**Subject:** Century Tire Plaza – 195 Kennebec Street

**Project ID# 2015-027**

**Review Comments Received from Planning Department**

**SITE PLAN**  
SCALE: 1"=20'

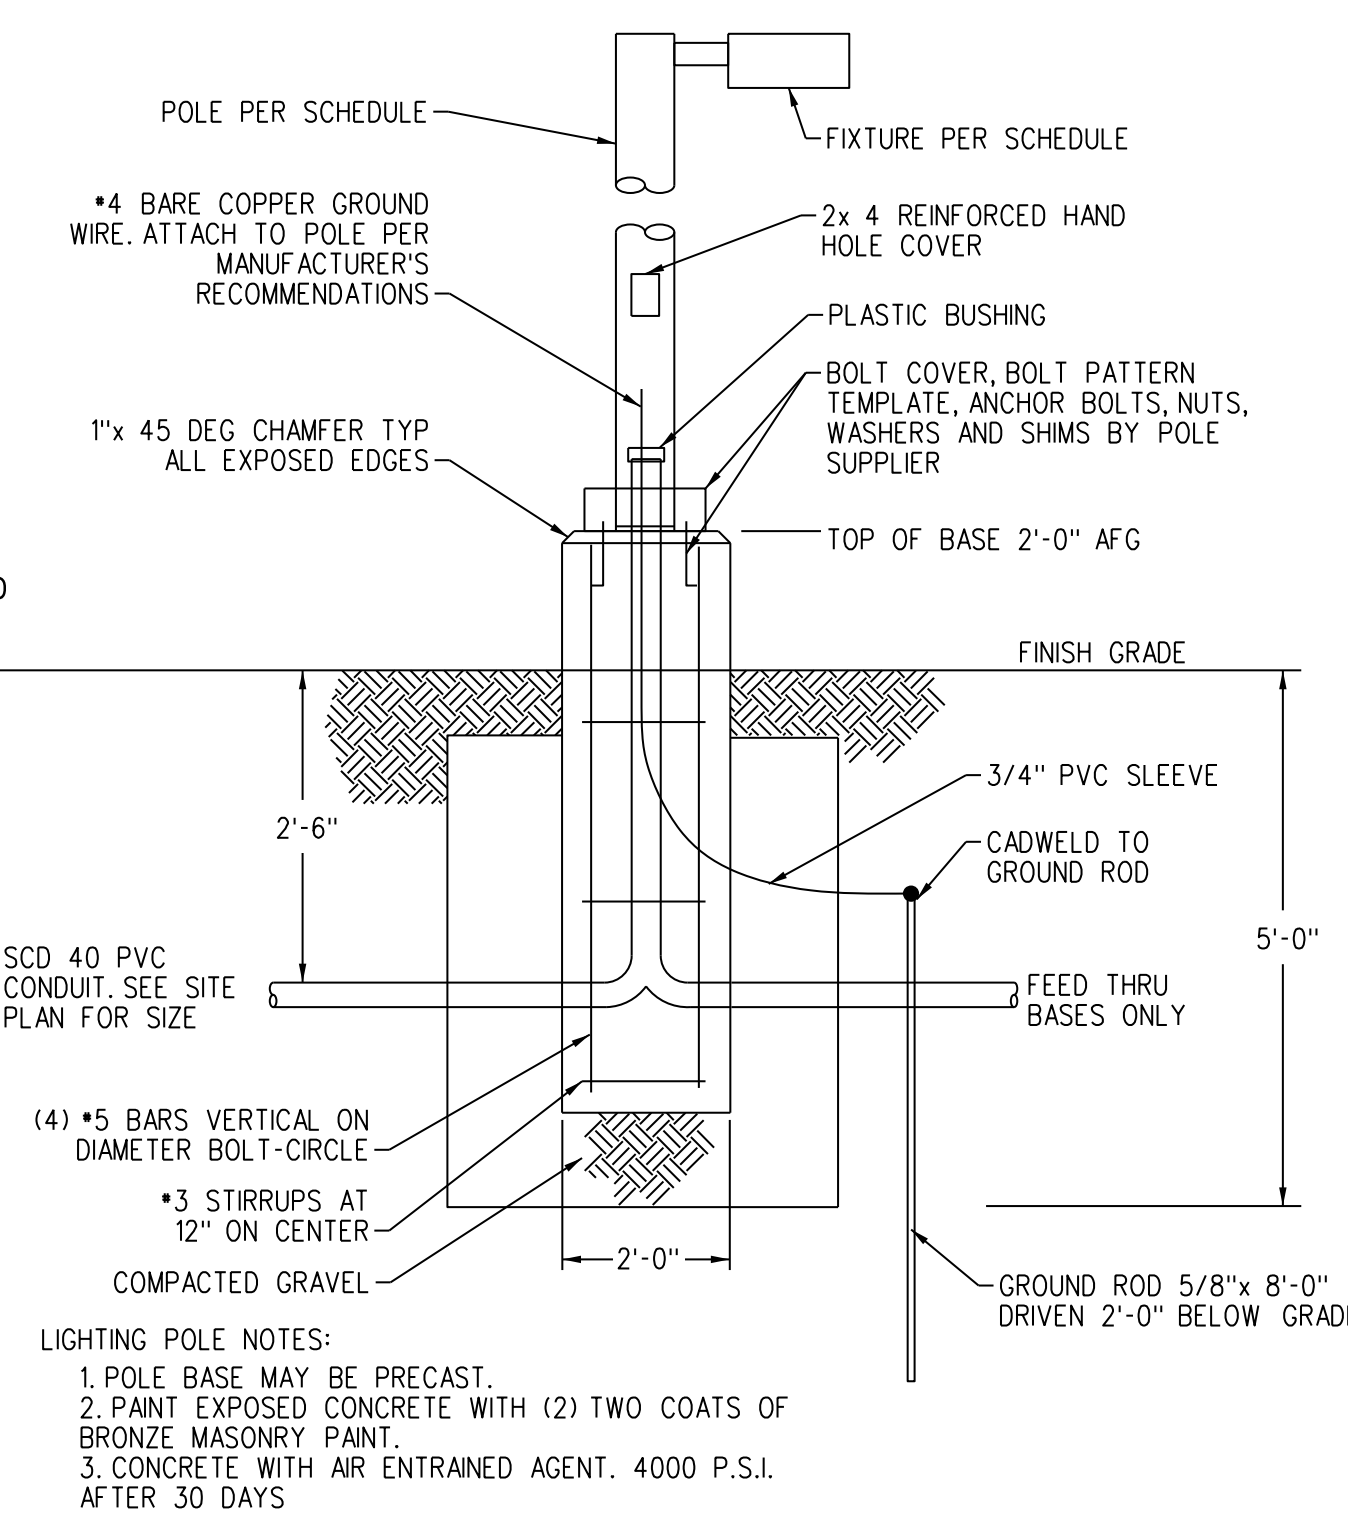
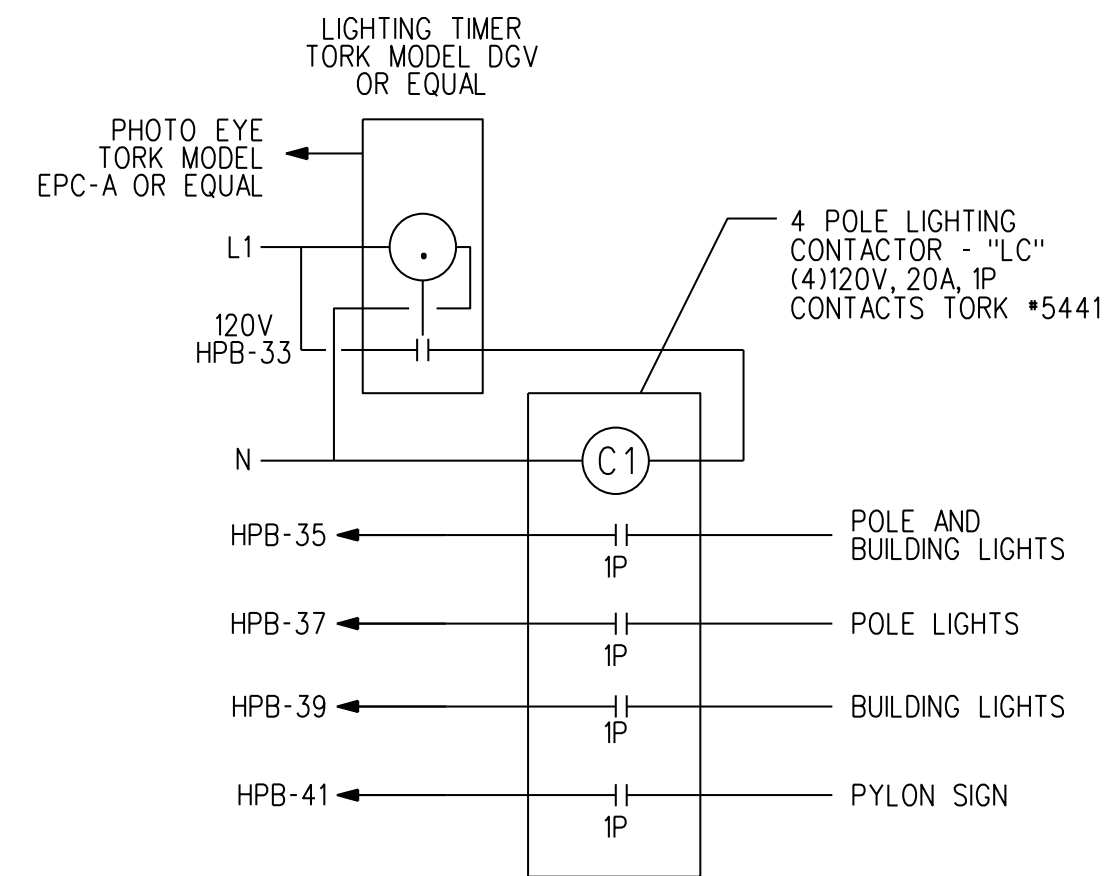
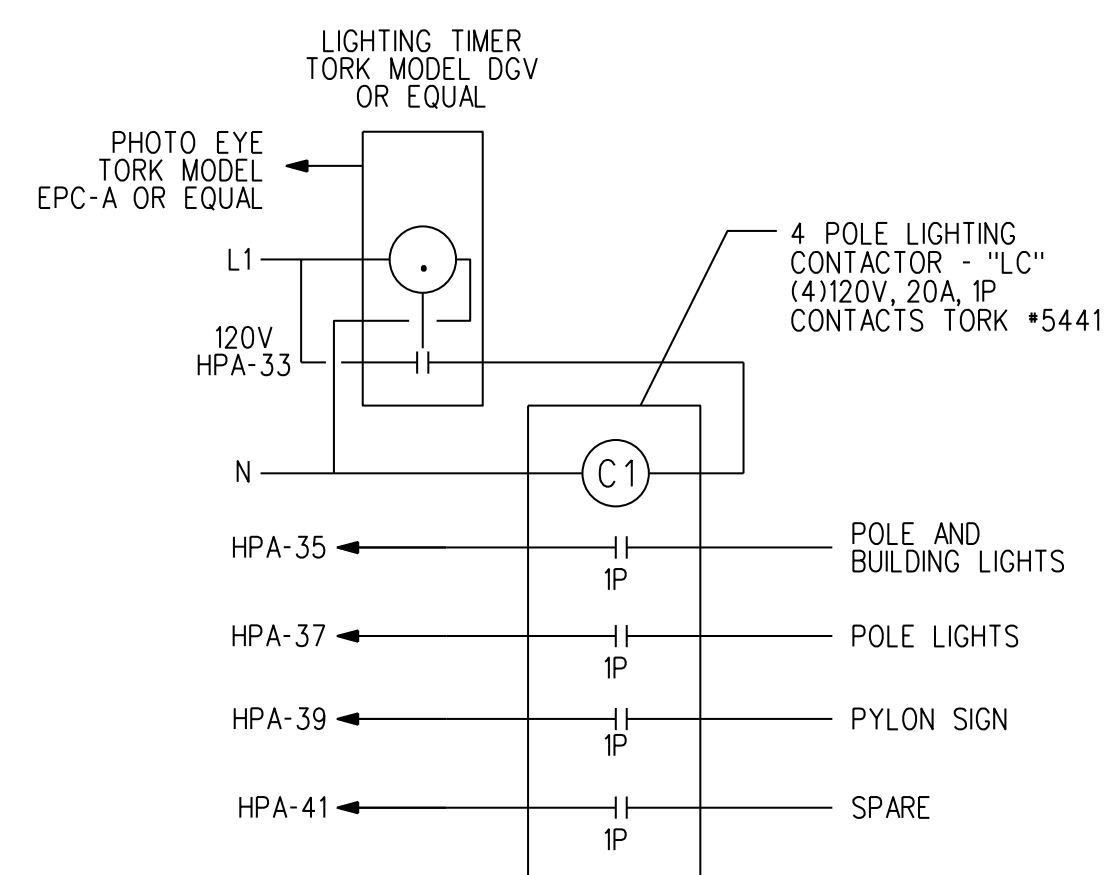
Please add a note stating that the street light fixtures will be LED.

The street light note on the Site Layout Plan (C-3.0) has been revised to include that the proposed light fixtures will be LED.
